# CITY OF ALBUQUERQUE

November 11, 2014

**RE: Coronado Center Longhorn Restaurant  
Erosion and Sediment Control (ESC) Plan (H18E005C)  
Engineers Stamp Dates 10-26-14**

SHEET TITLE  
**EROSION CONTROL  
PLAN**

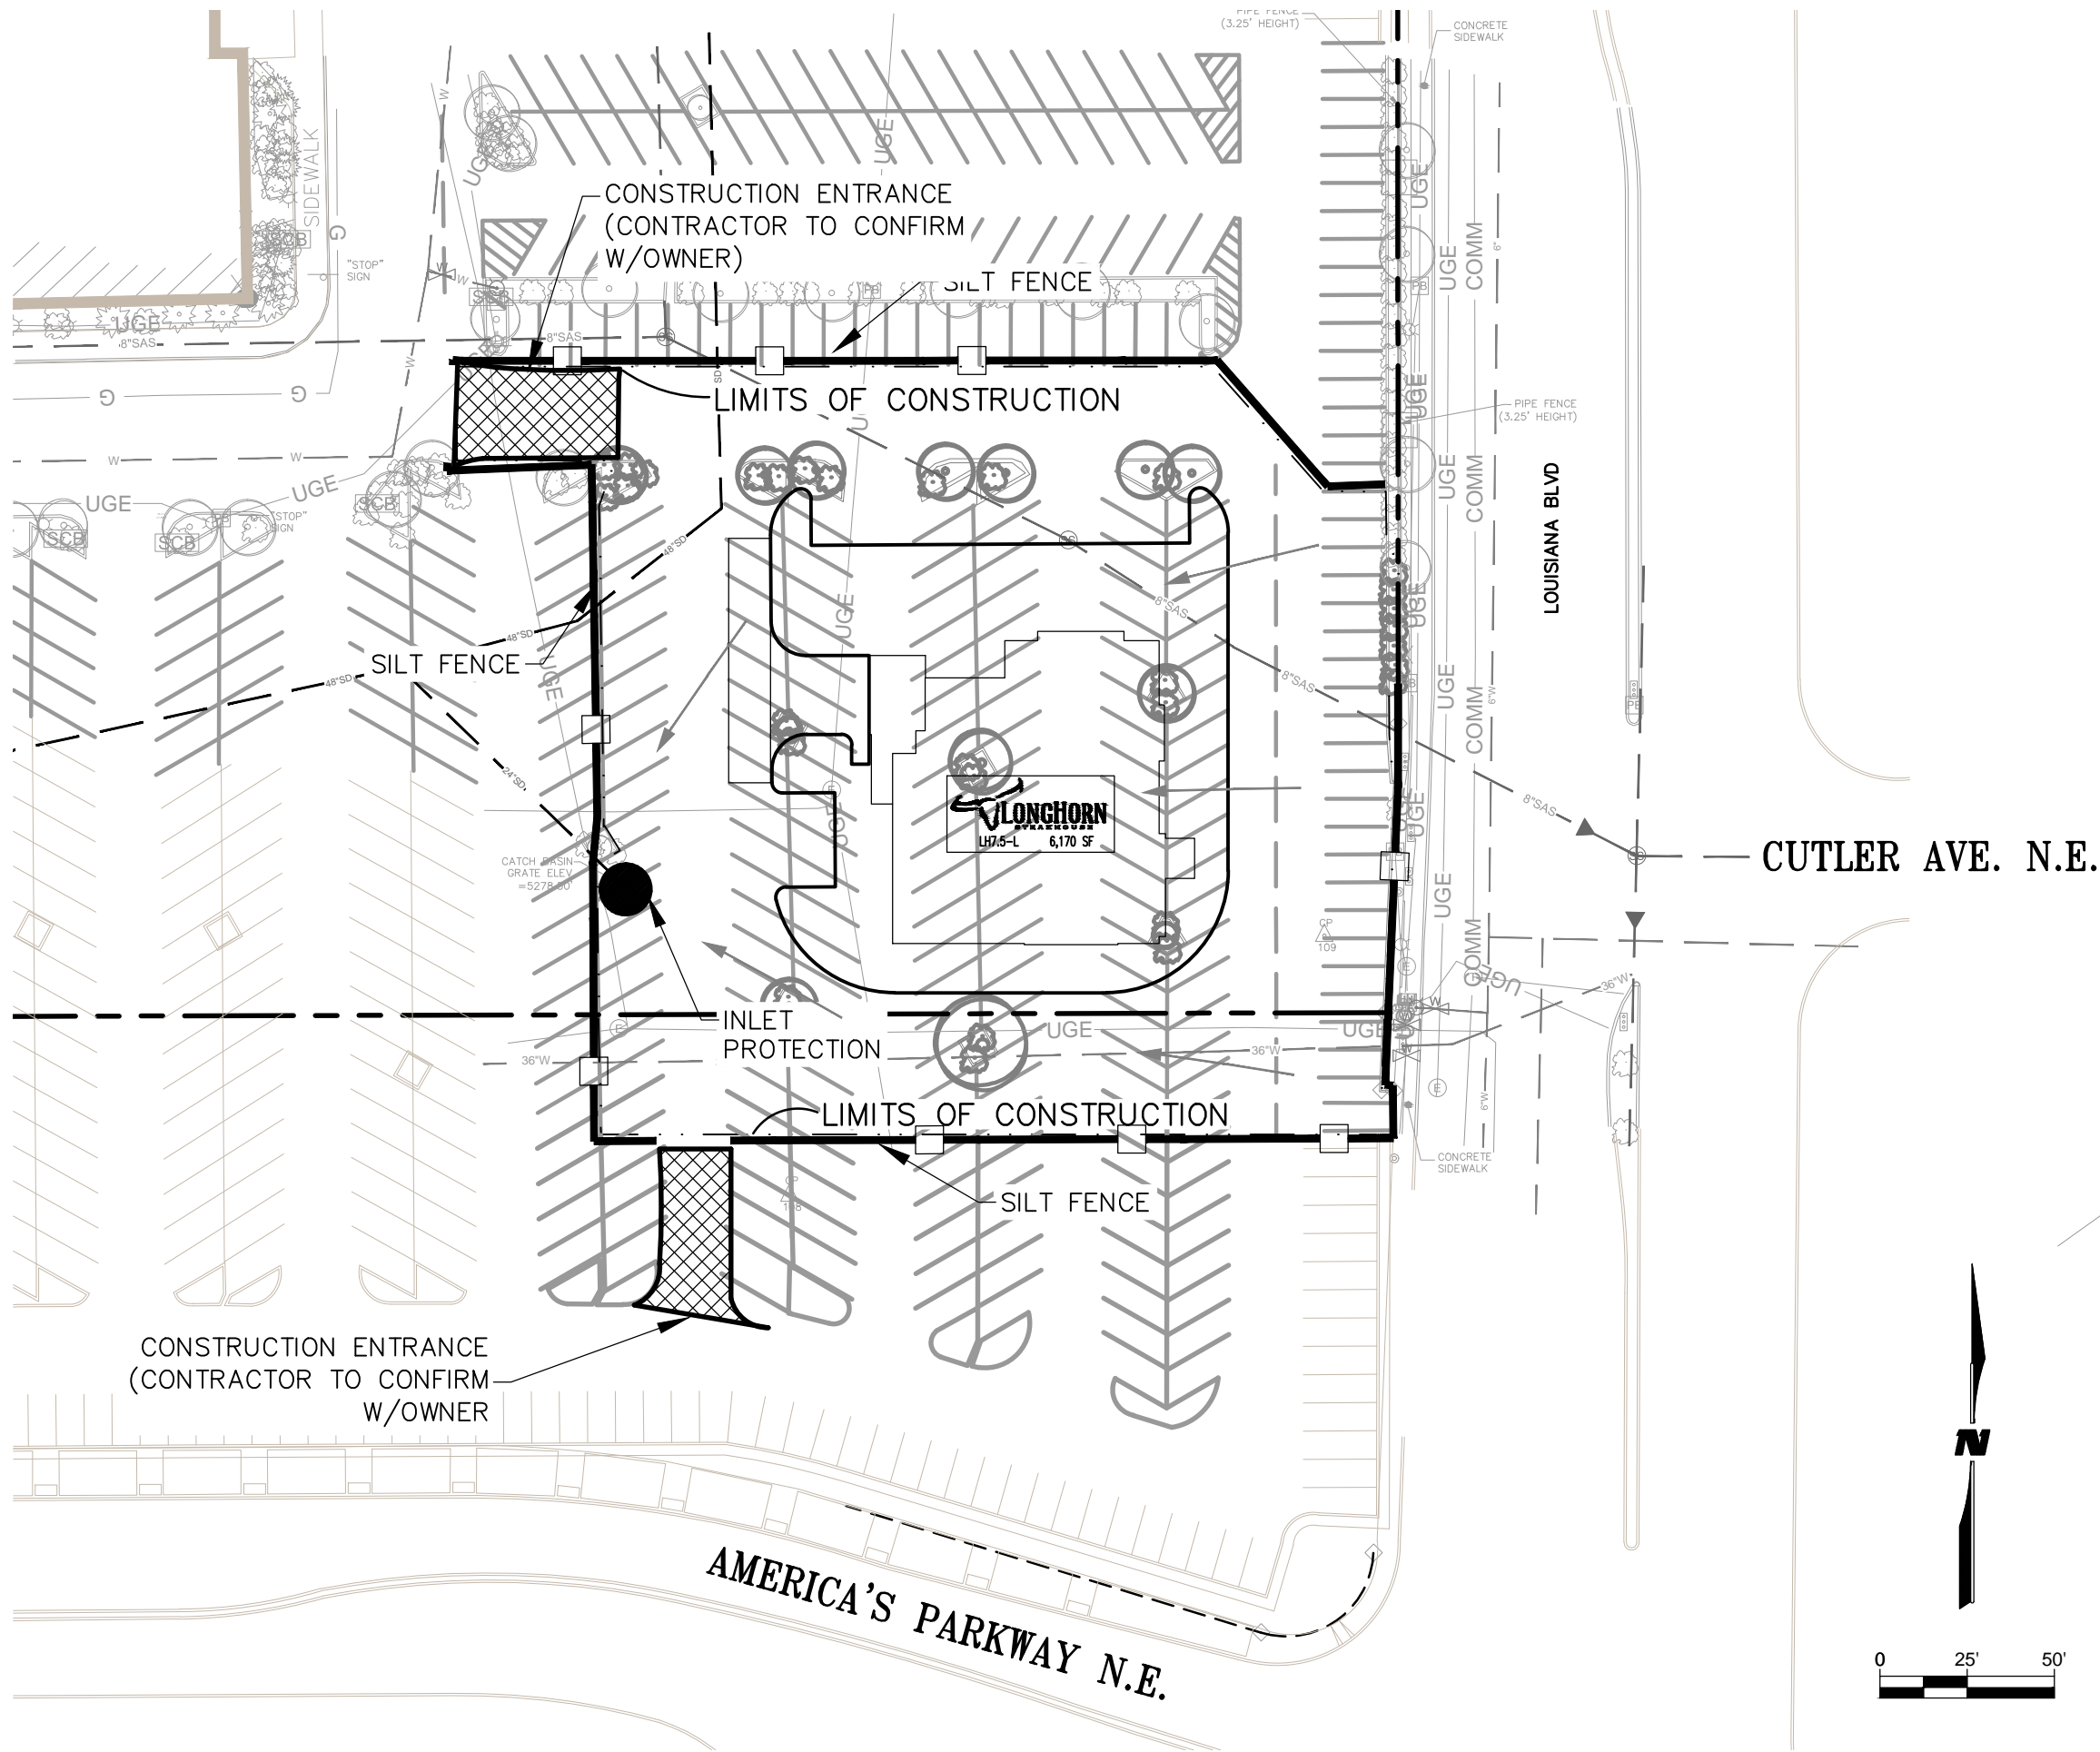
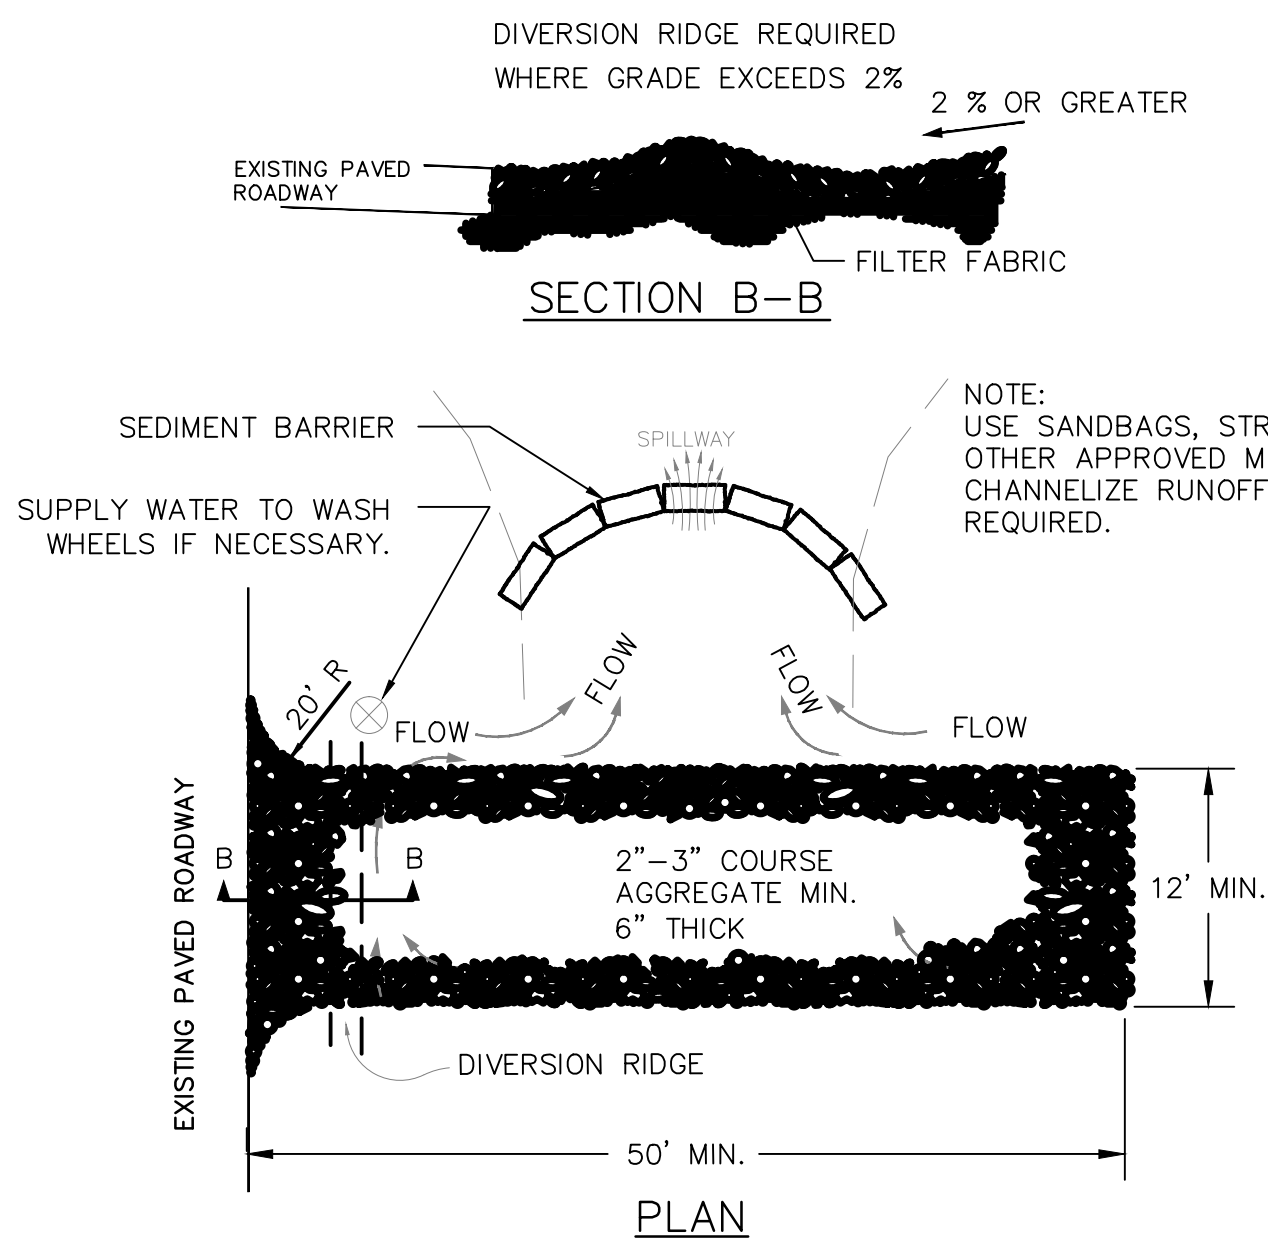
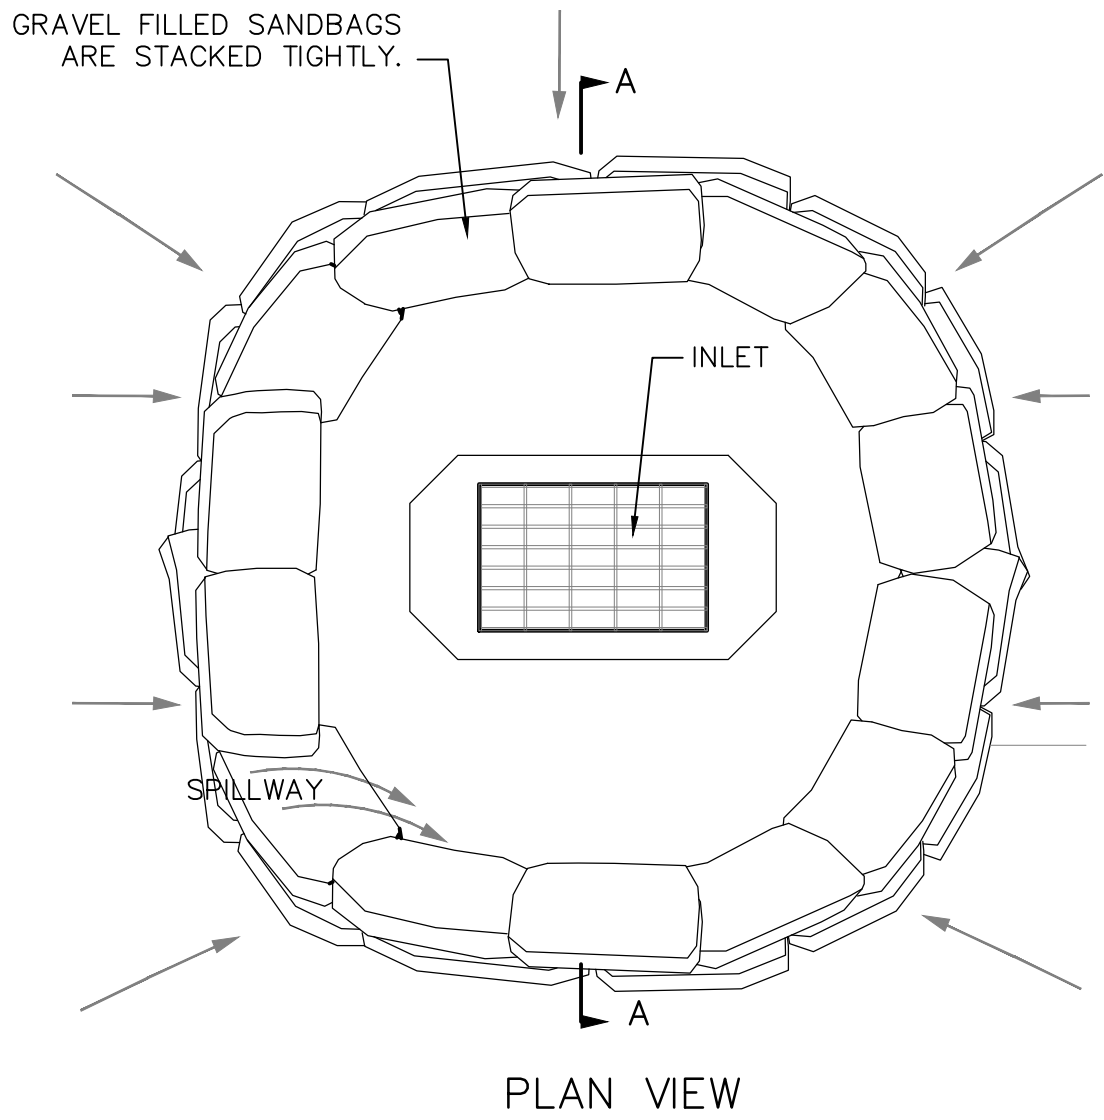
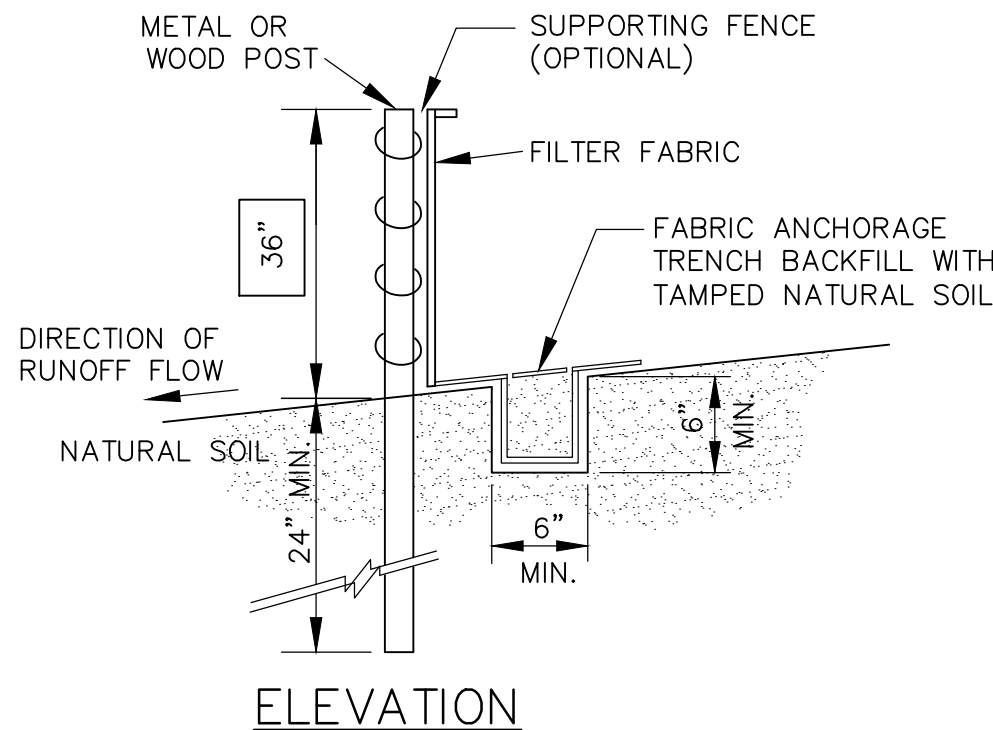
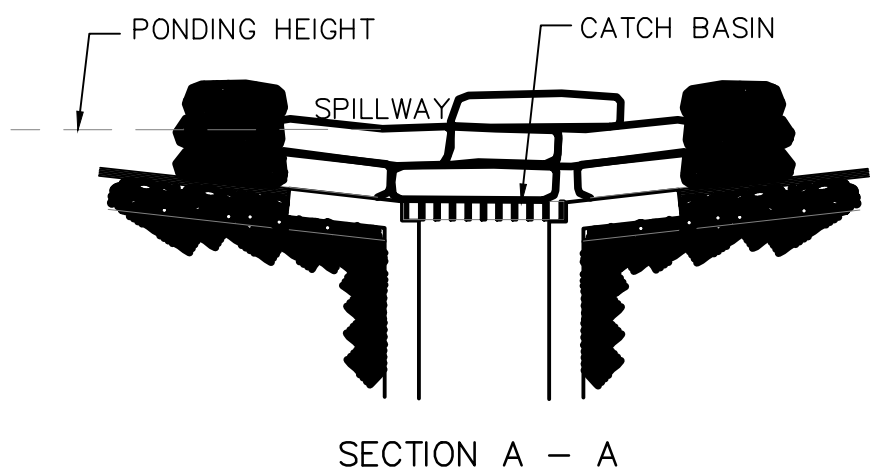
\_ Include NPDES Posting Board. Posting Board should be visible from Public Street.
